Demolish existing sunroom, lean to canopy, and partially demolish existing garage.
Erect side and rear extensions including replacement garage. Alterations to fenestration and external materials. Create additional access to private road for 'in and out' driveway.
25 Myrtle Grove East Preston

Thank you for your internet representation made on 26th March 2019 which has been recorded as '**an objection**' with the comments as follows:

Application Number EP/20/19/HH

PROPOSED SITE PLAN

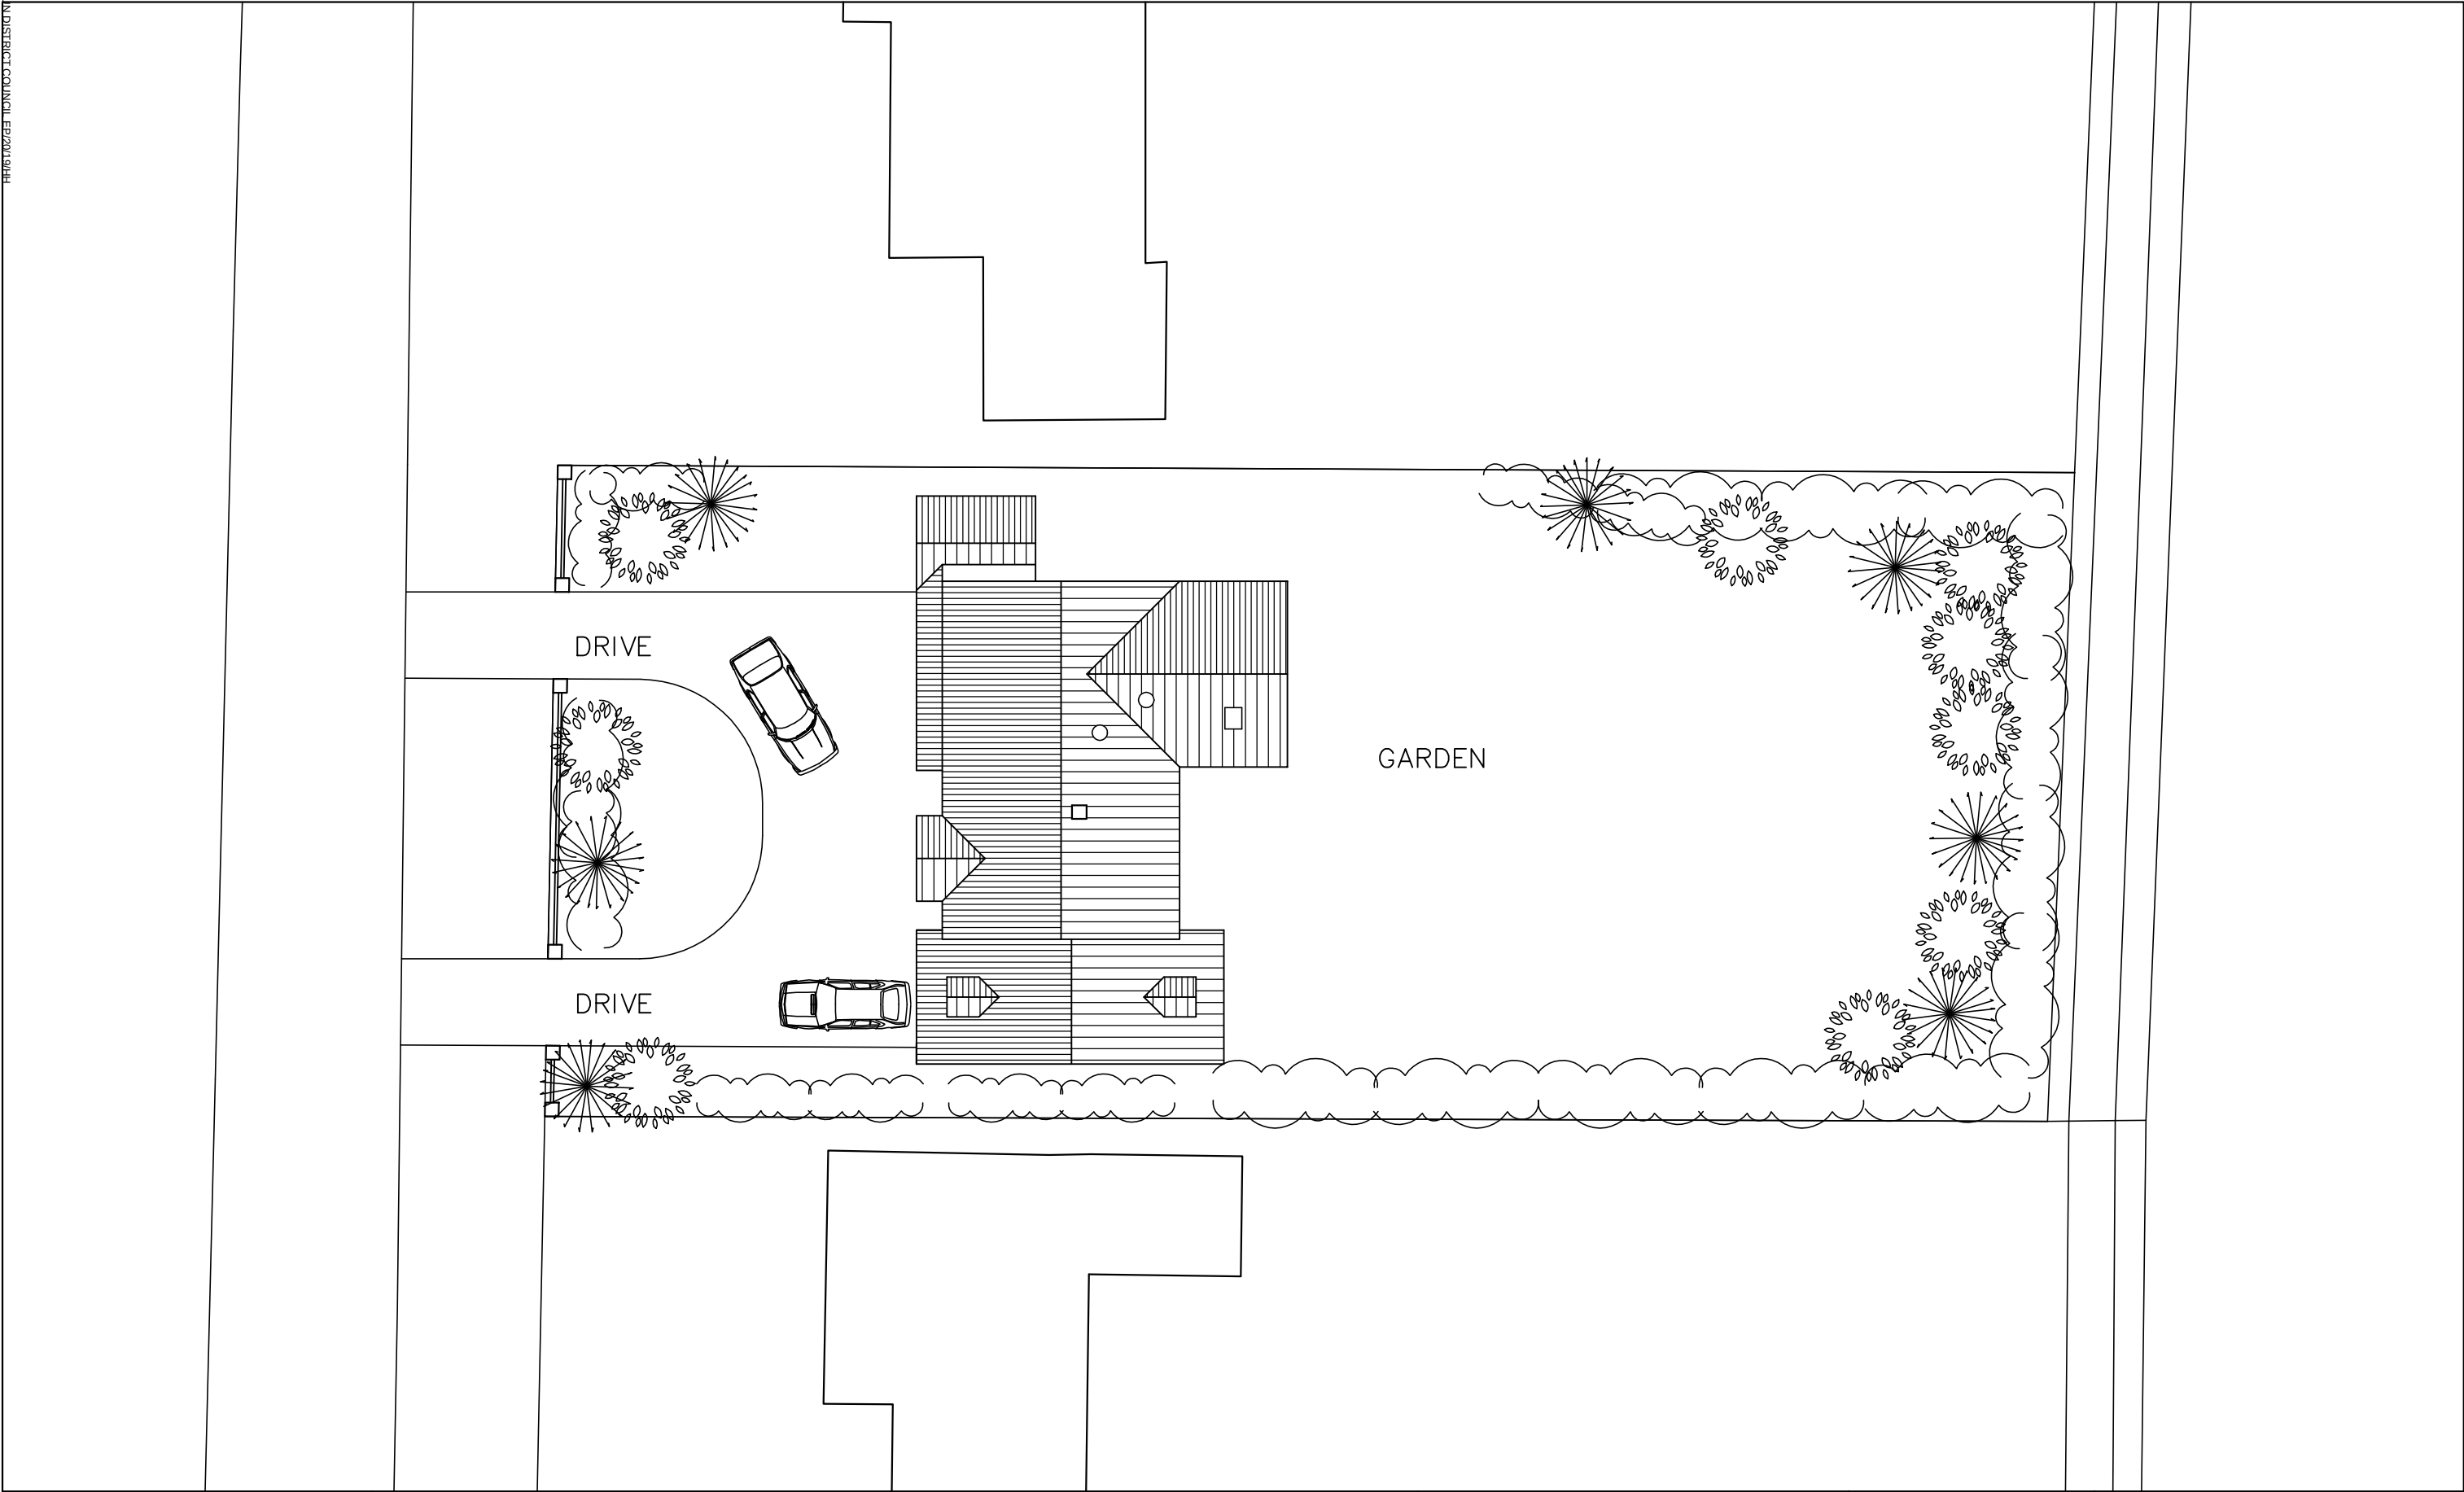
2. The plans show an alteration to the vehicle and pedestrian access. The increased in out drive area indicates that the proposed materials are gravel with block edging.

- On a quiet, private estate with a relatively low volume of traffic the noise created by, the at present four, vehicles access will be significant.*

PROPOSED ELEVATIONS

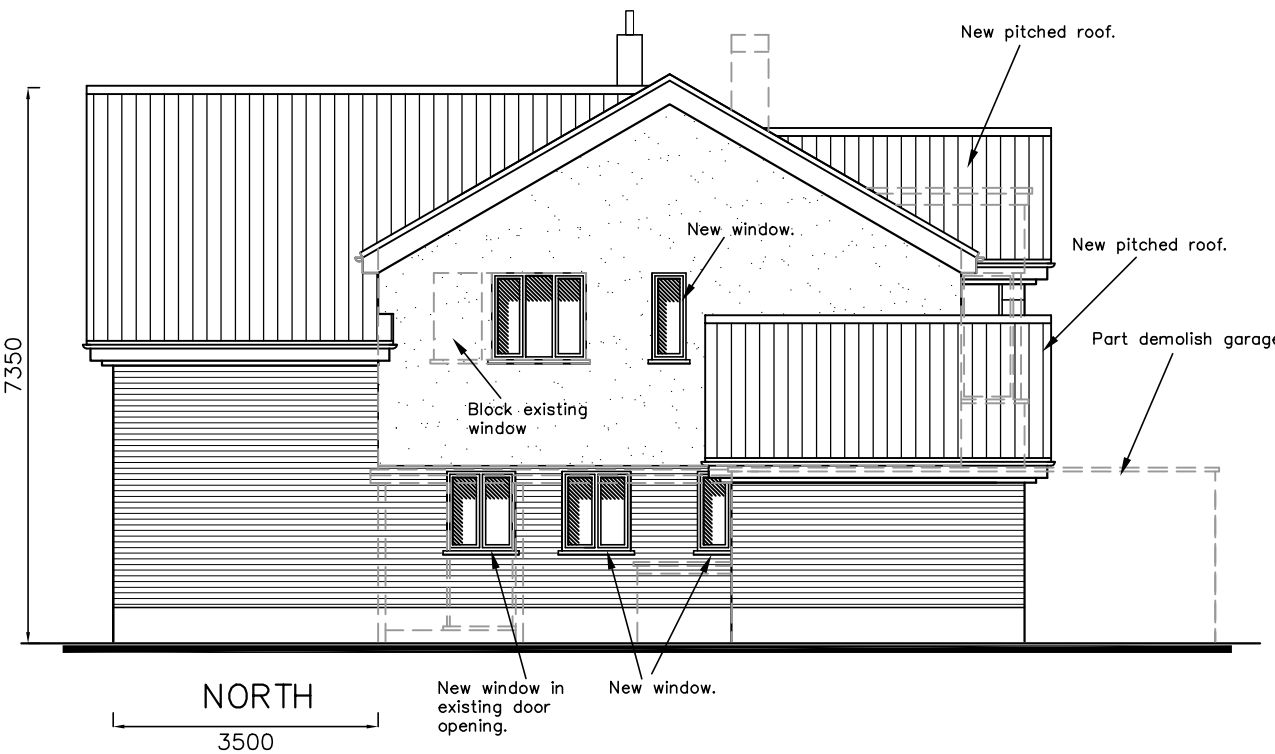
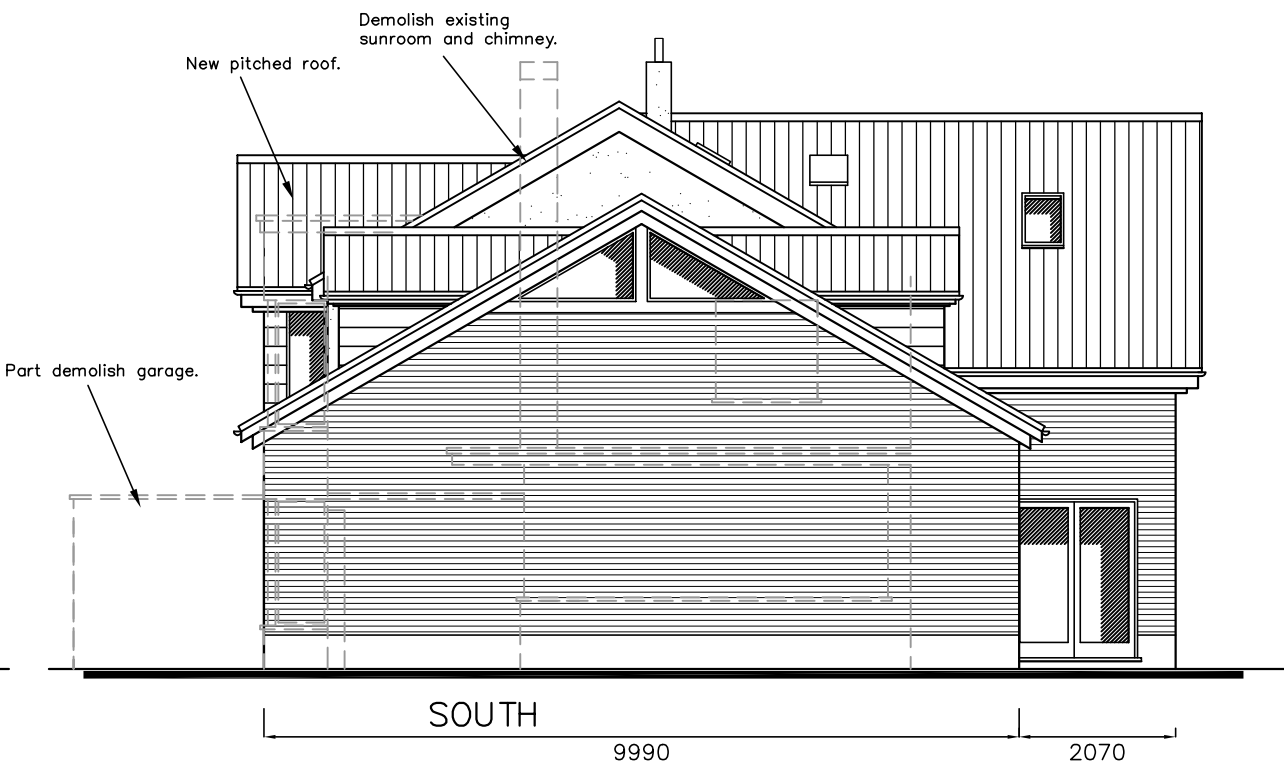
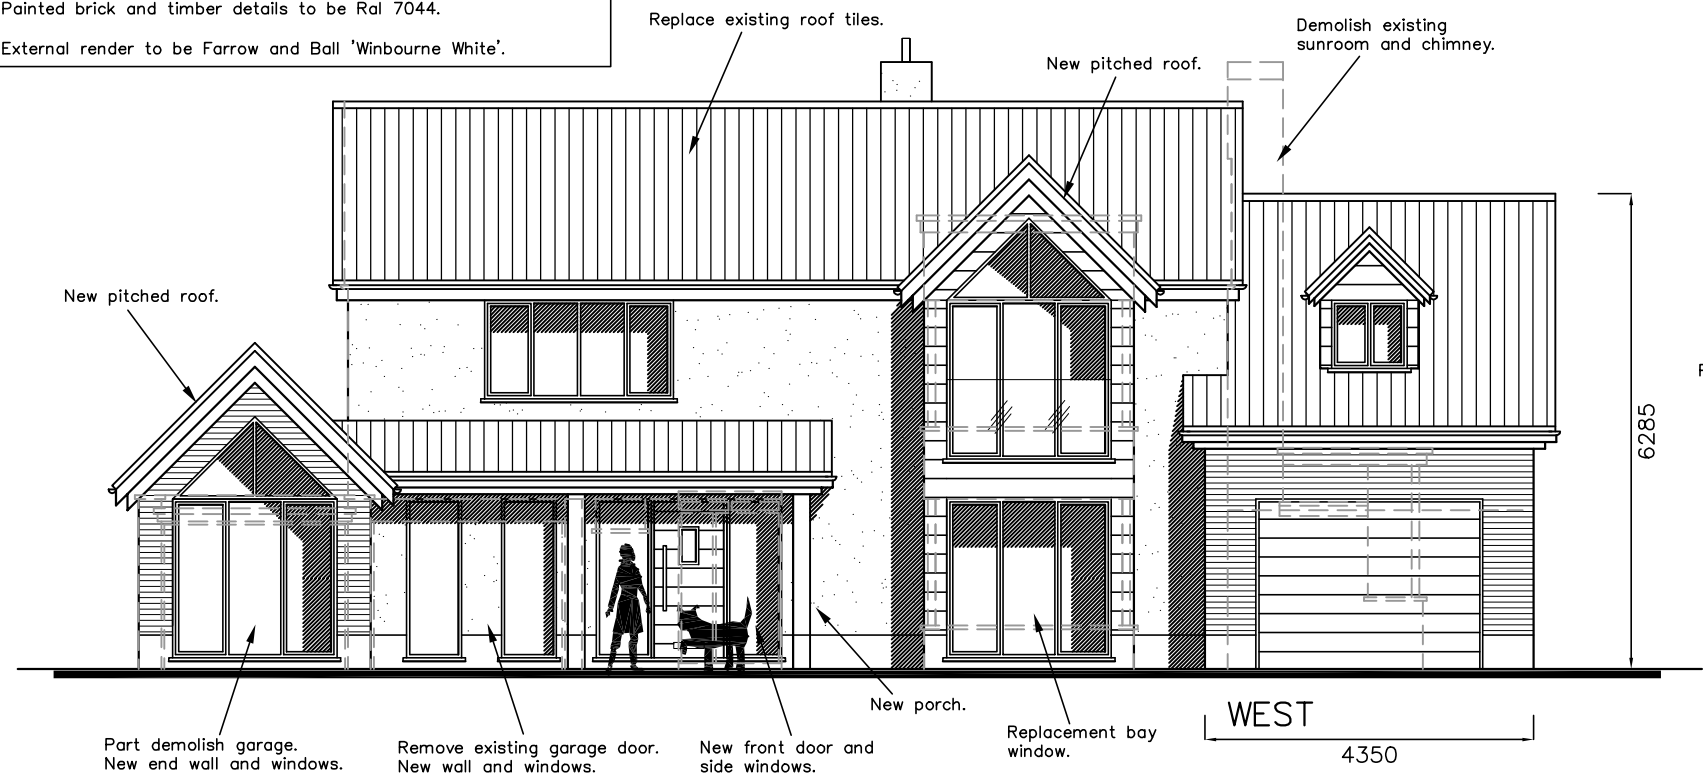
1. The proposed plans show an extension, on the east aspect, of 3500 in length from the current building line with a height of 7350 to the ridge tile which is considerably higher than the nearest property to the north, a chalet bungalow. The total extent of the proposed building will be a length of 5600 from the bungalow's main building line and the living area of the property.

- It follows that there will be an effect on the level of daylight to that existing property.*
- As the sun tracks to the west the amount of shadowing will affect the use of the patio area, lounge and upper garden area.*
- The present quality of life enjoyed by the householder will be impaired.*
